Our Ref: LU/278/19/HH
Your Ref:

Town & Country Planning Act 1990 (as amended)
Town & Country Planning (Development Management Procedure) (England) Order 2015
Application for Planning Permission for Works or Extension to a Dwelling

Development Removal of existing Porch and construction of front extension
Location 37 The Estuary Littlehampton

Block Plan - Proposed

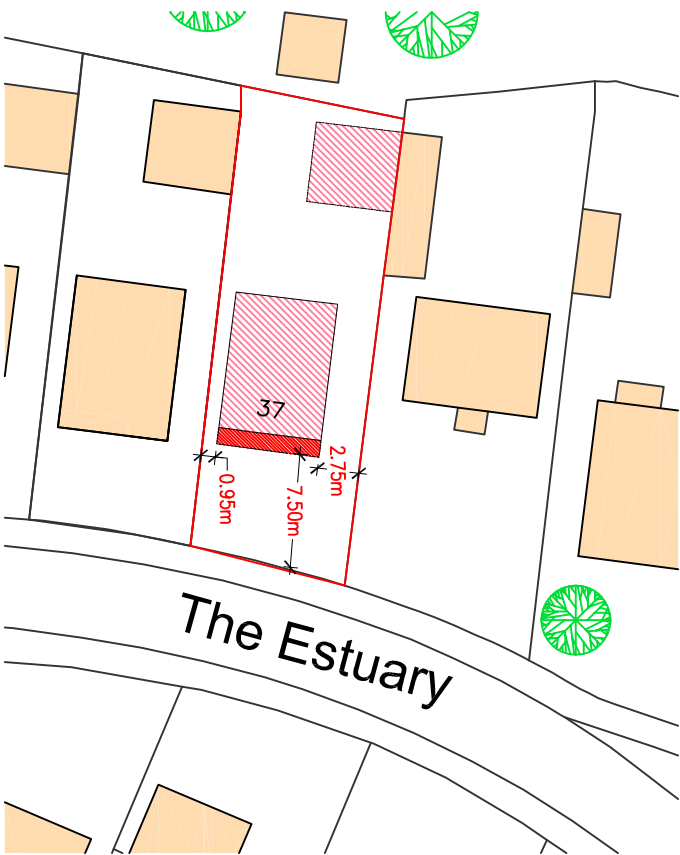
Block Plan

You are required to include dimensions from the proposed extensions to all site boundaries.
